13 December 2019

Our Ref: R/2017/11/I
File No: 2019/630726

**Response to Submissions - ATP Locomotive Workshop (Bays 5-15)
SSD 8449 MOD 4 - 2 Locomotive Street, Eveleigh 2015**

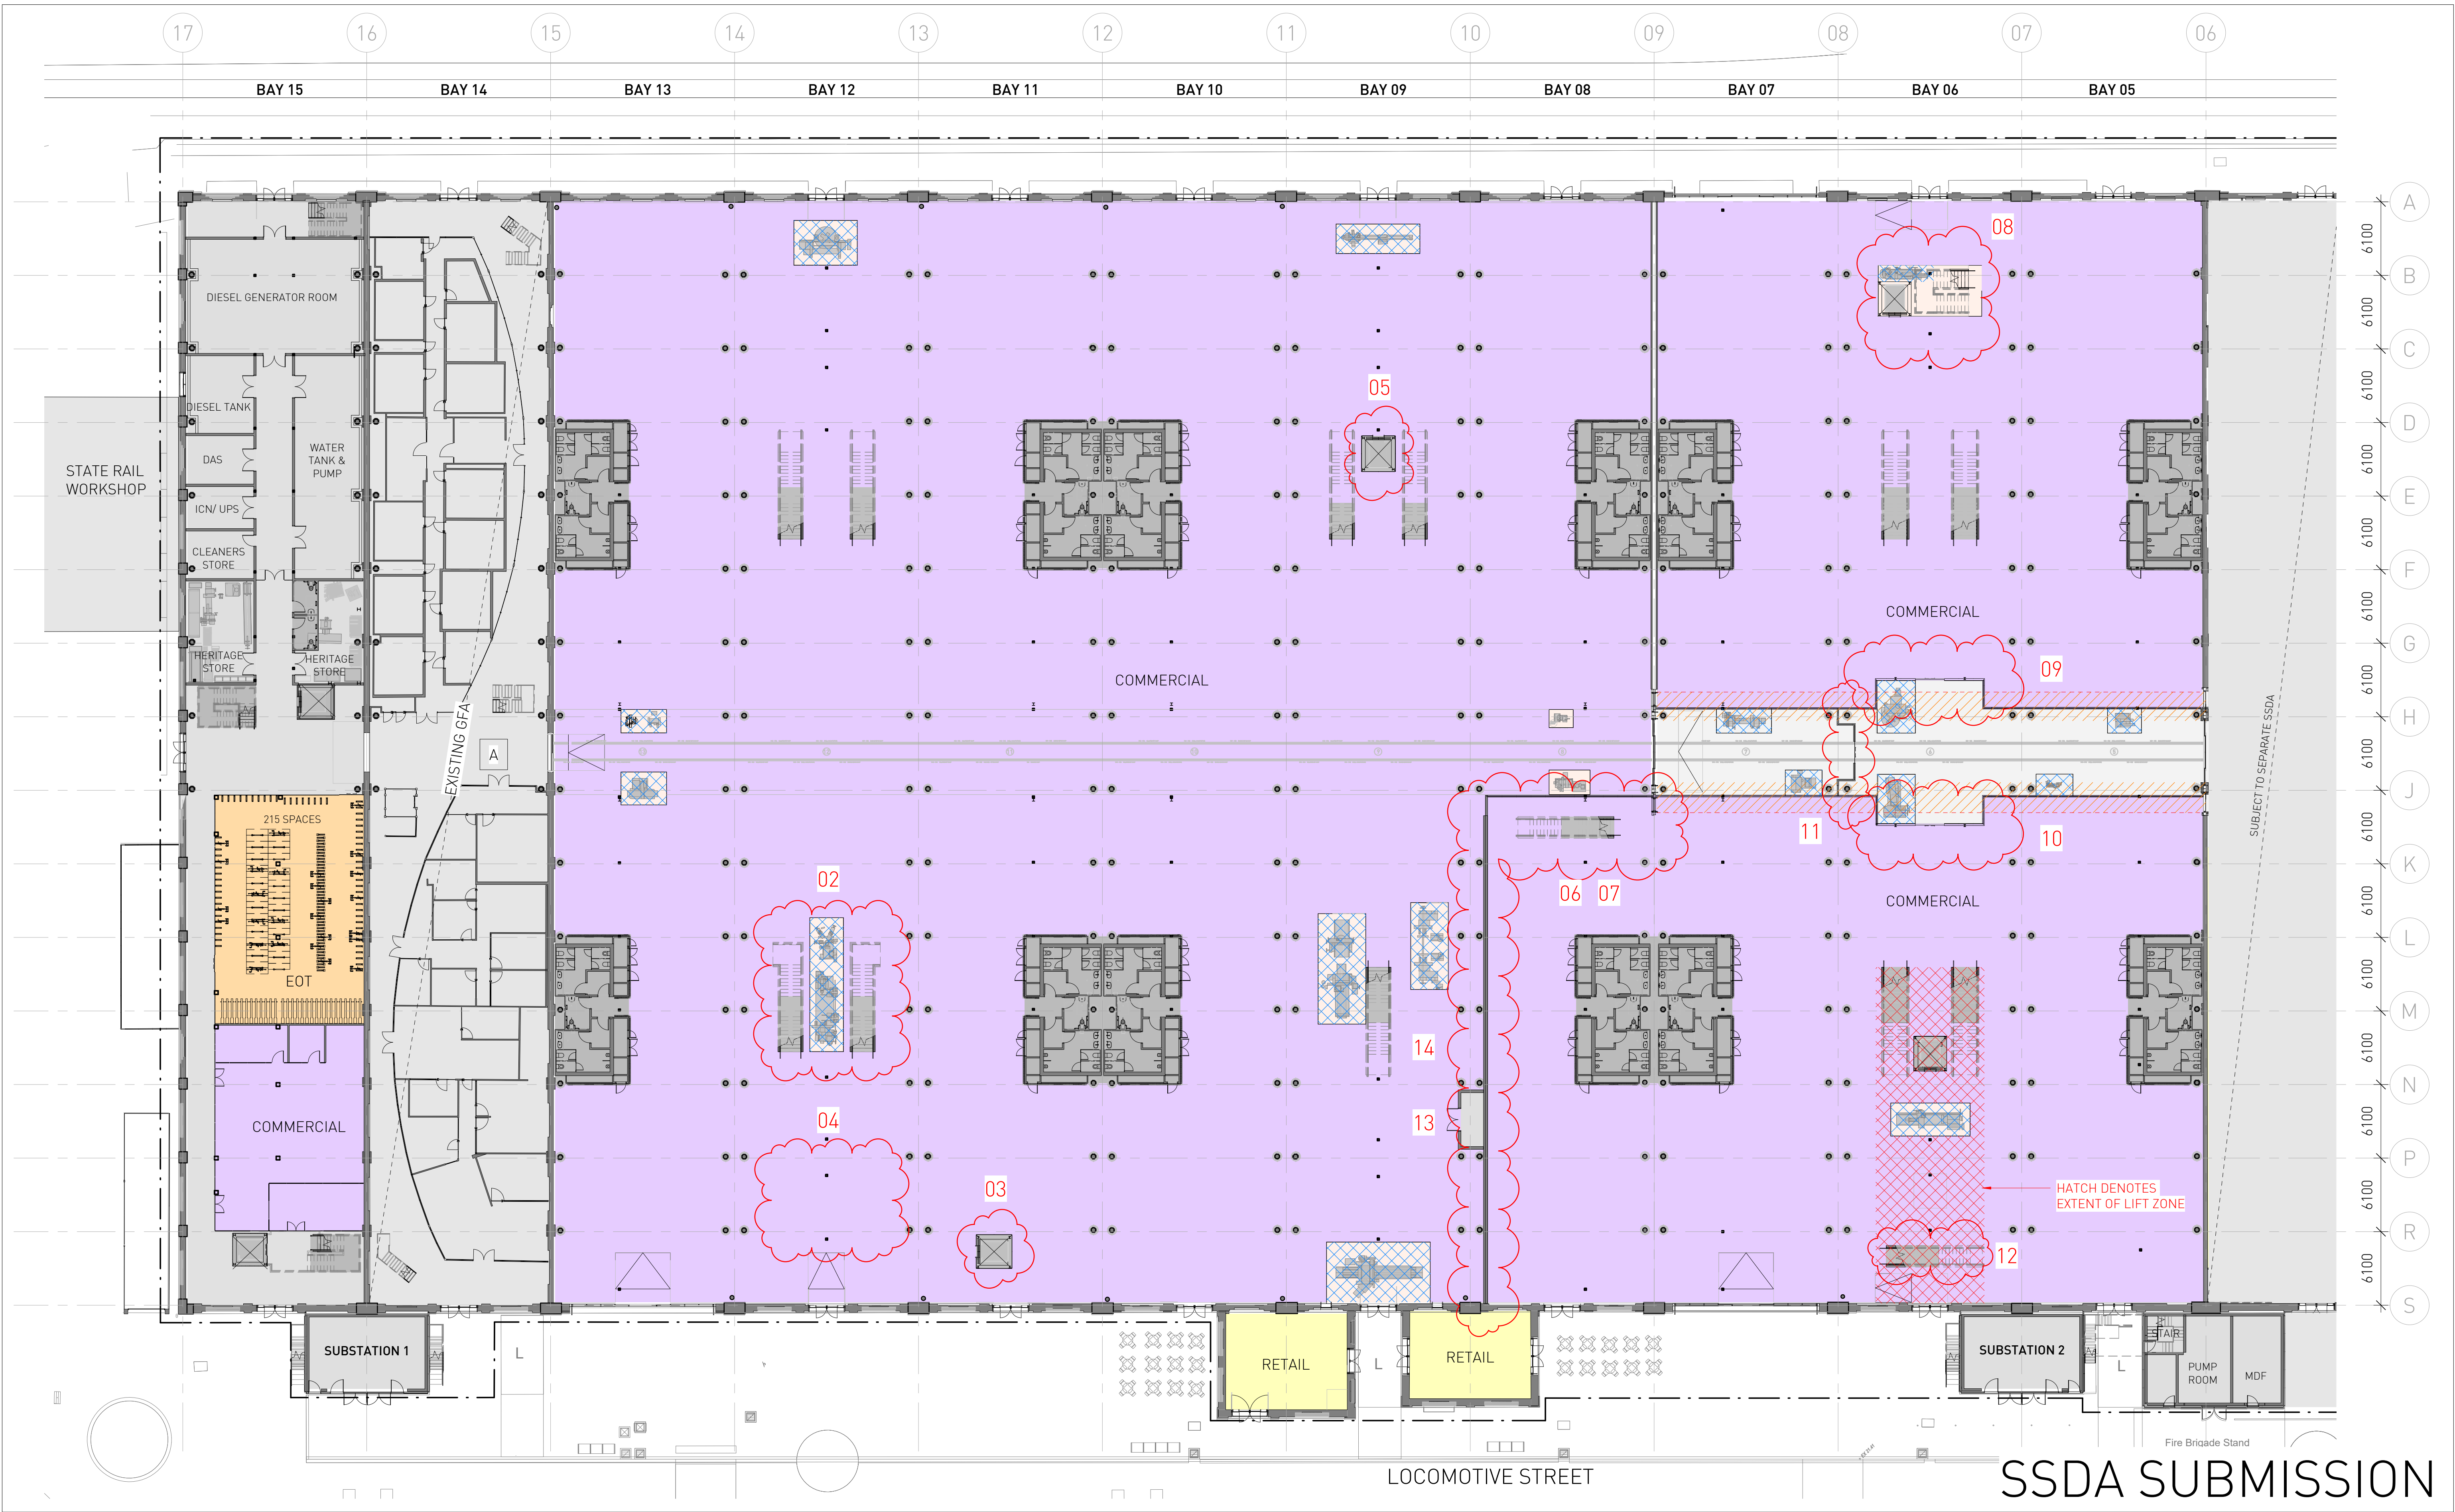
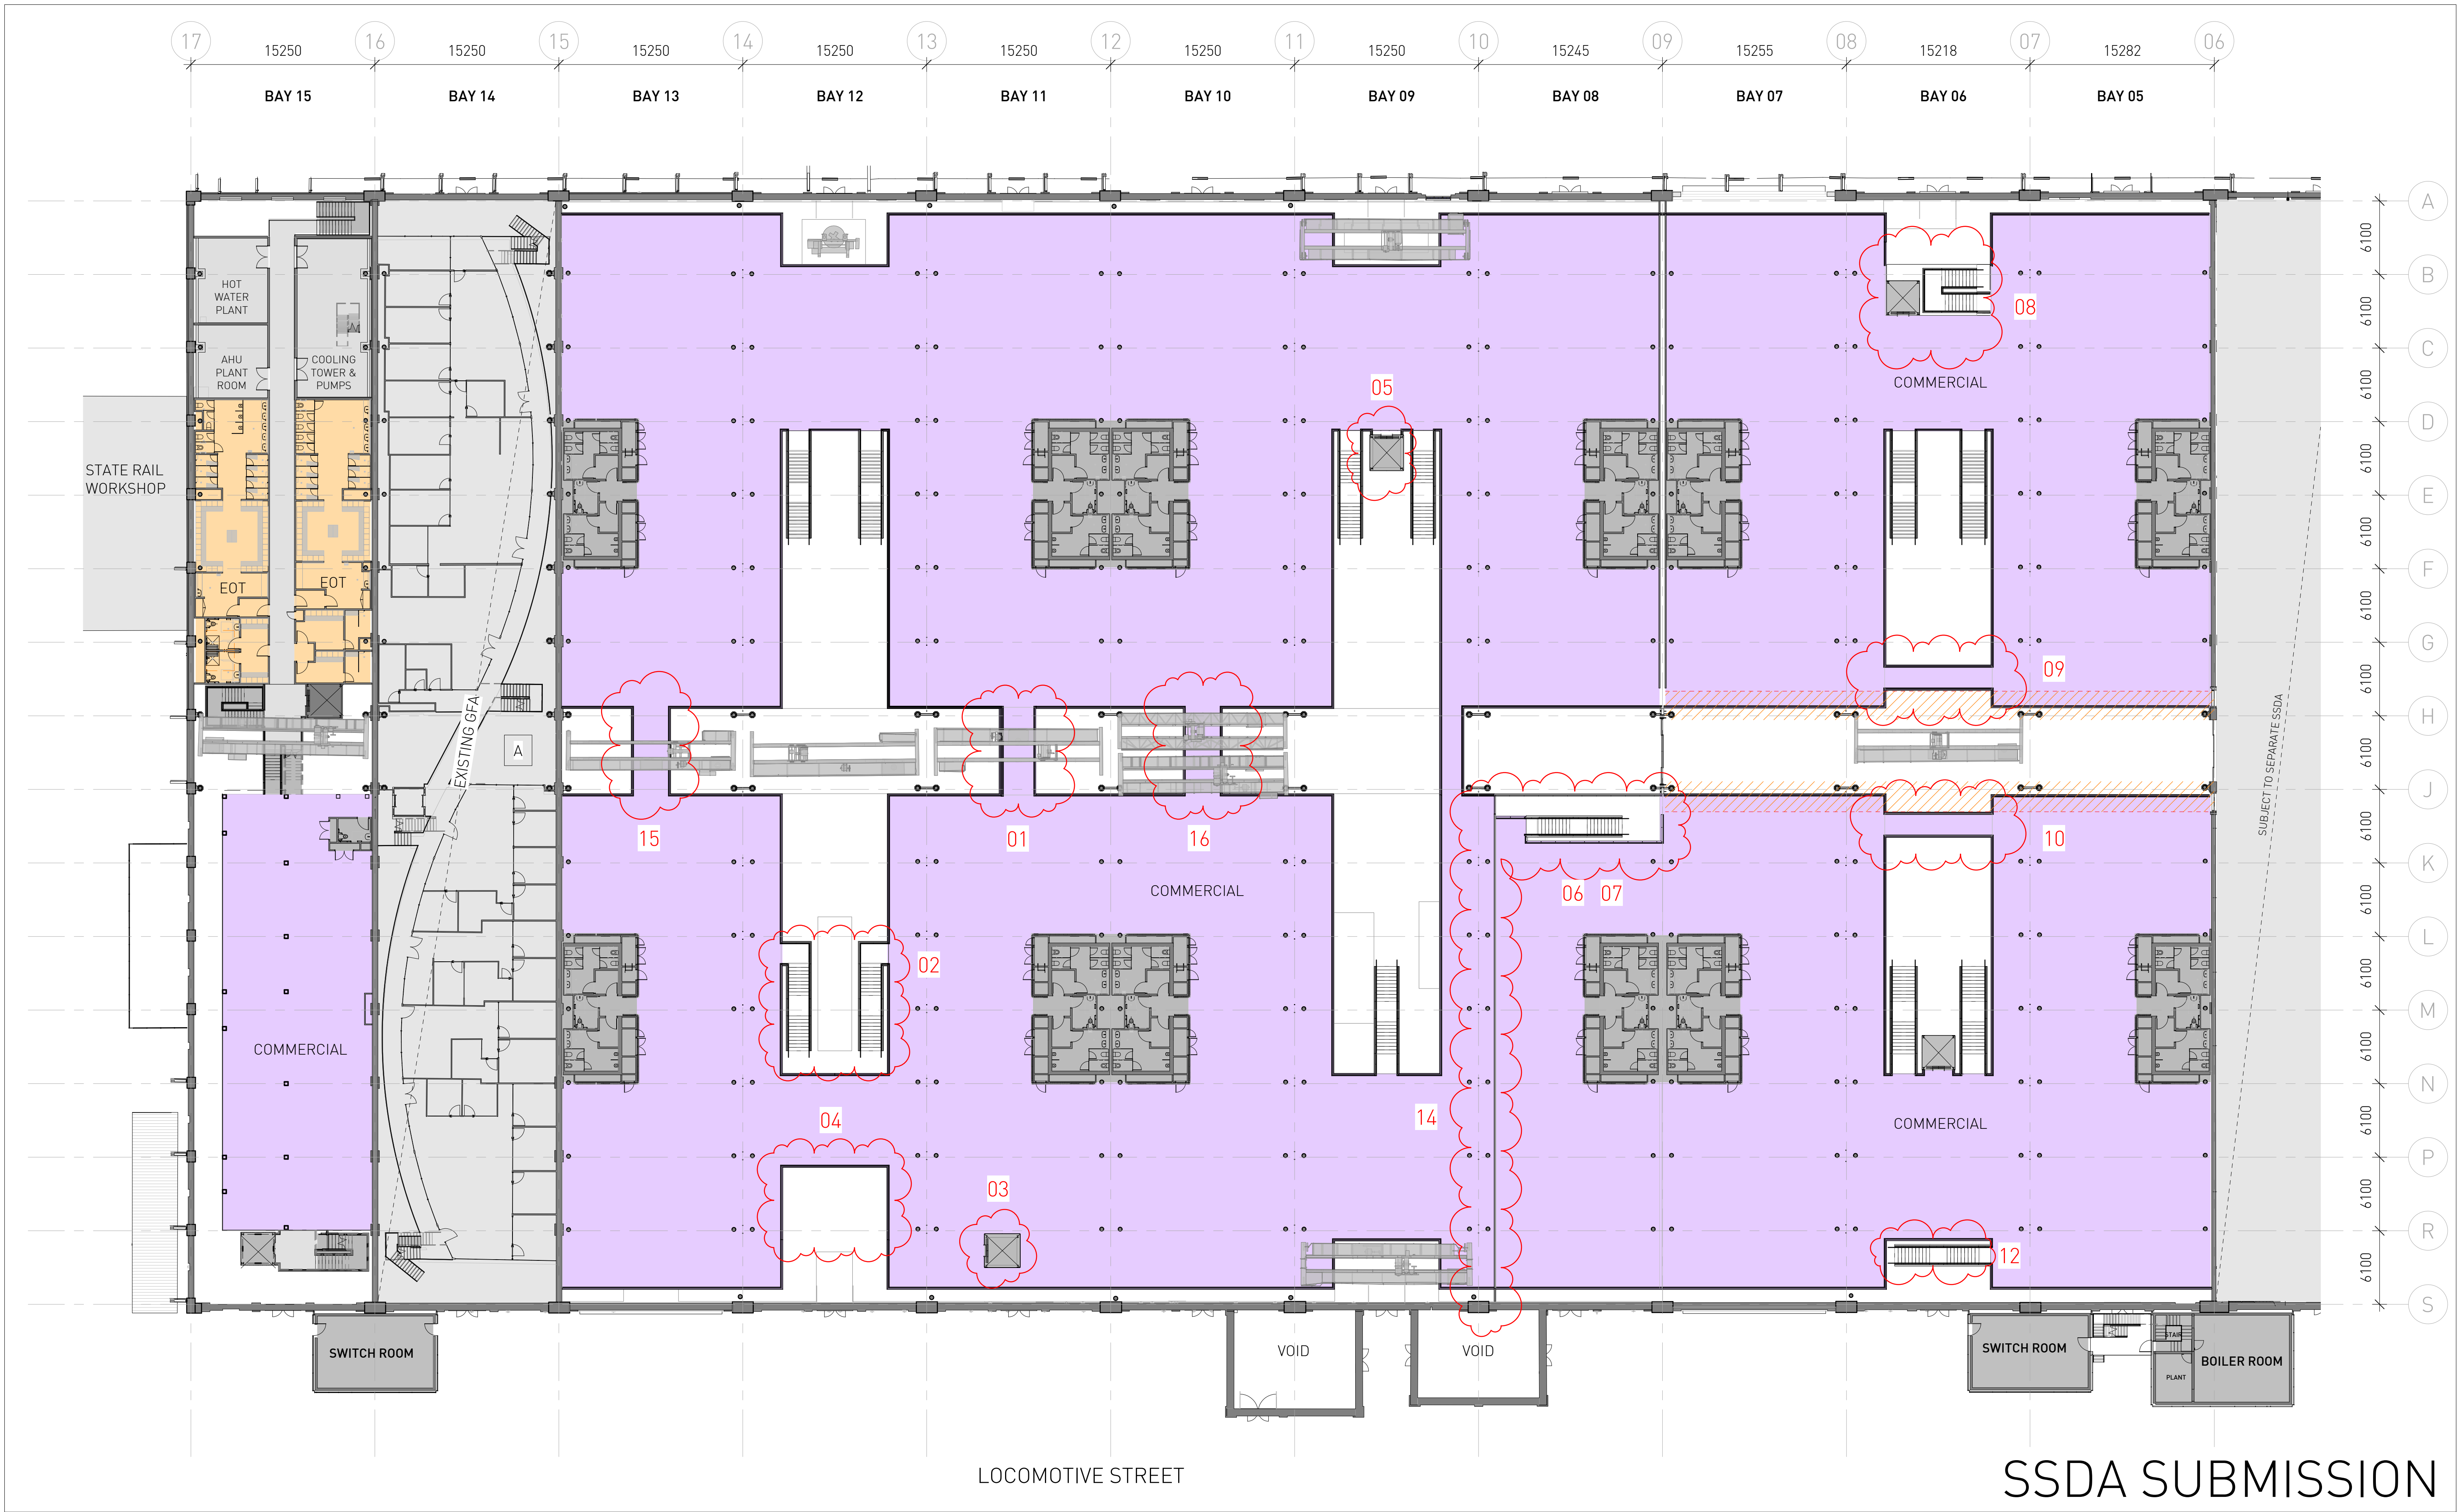
The City also raised concern for the inconsistencies of the Heritage Impact Statement (HIS) in our objection letter dated 4 November 2019. It is acknowledged that the error in the HIS relating to the reconfiguration of the link bridge at Bay 10 Central has been rectified. However, the revised architectural plans submitted with the RTS illustrate 2 link bridges within Bay 10 and do not demonstrate "a widened and centred" bridge to align

with circulation across the floor plates. Accordingly, it is recommended that the inconsistencies be addressed prior to any consent being granted for the modification application.

③ SK_0851 GRID 8 GLAZING - GROUND FLOOR PLAN
1:50

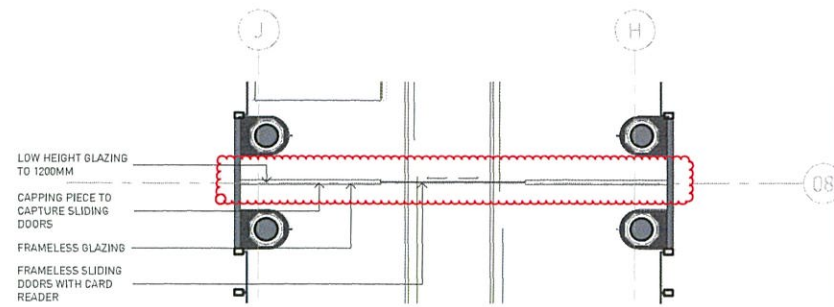
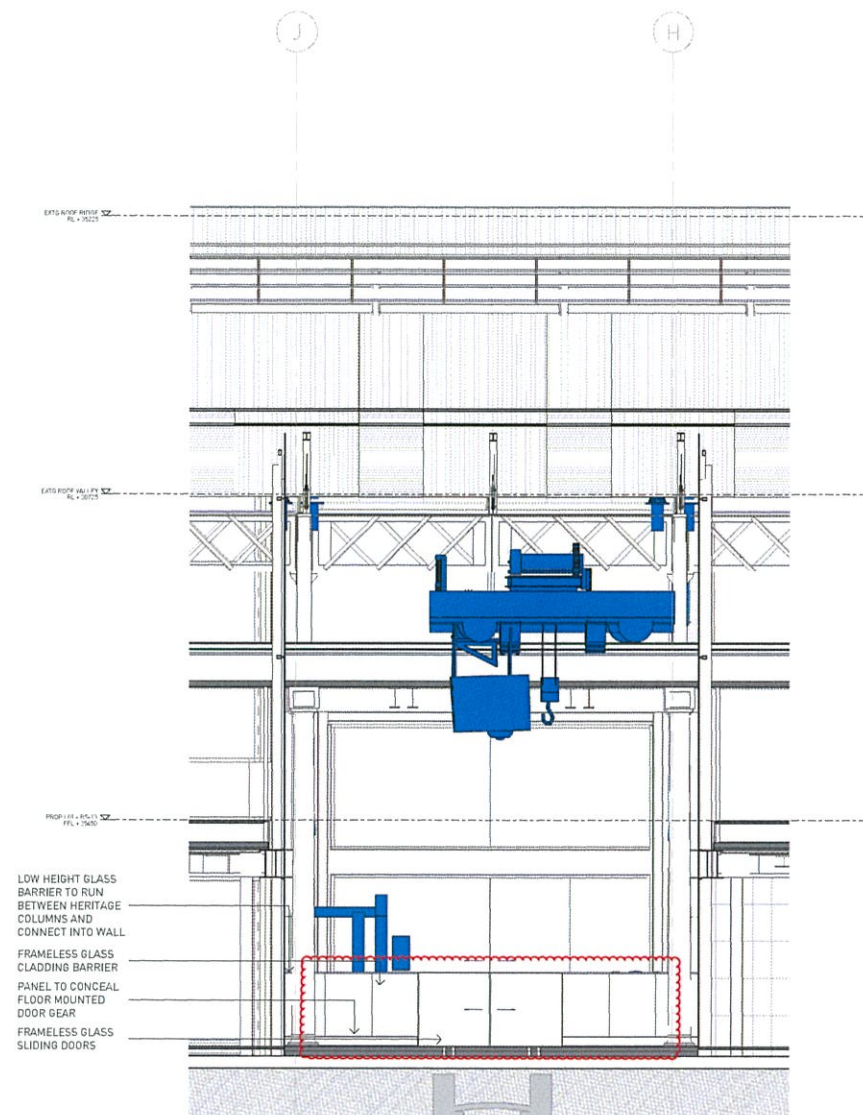
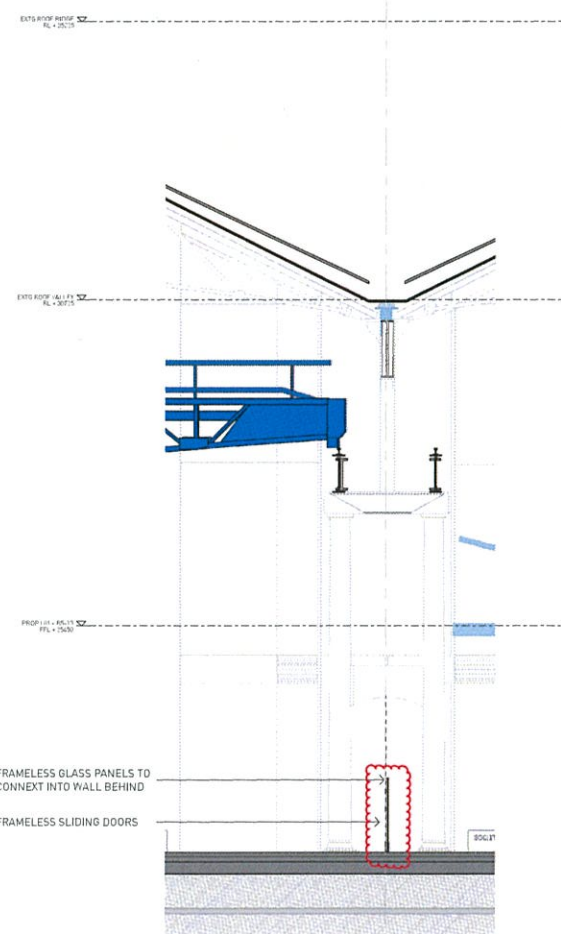
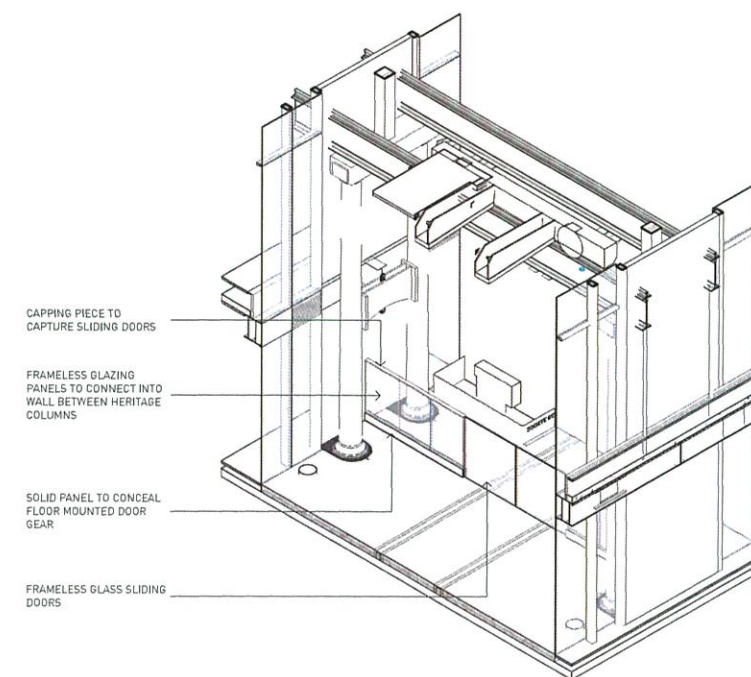
1. Addition of a Sliding door in Bay 8

The RTS Report, prepared by Ethos Urban, outlines the justification for the provision of the Sliding Door in Bay 8 is to ensure compliance with the BCA requirement of a 20m point of choice egress for the public. The selection of clear and frameless glazing is intended to minimise obstruction of views along the central spine and, overall, have a neutral visual impact.

Whilst the use of frameless and transparent glazing would allow for visual continuity of sightlines along the central spine, the proposed structures are incongruous and would obstruct the openness of the corridor that is discernibly free from structures. The sliding door is a redundant measure to restrict the public into the central spine and would still permit the public to traverse elsewhere within the Locomotive Workshop. Therefore, the proposed modification so as to comply with the BCA is unconvincing and the City highly recommends that an alternative design solution be explored.
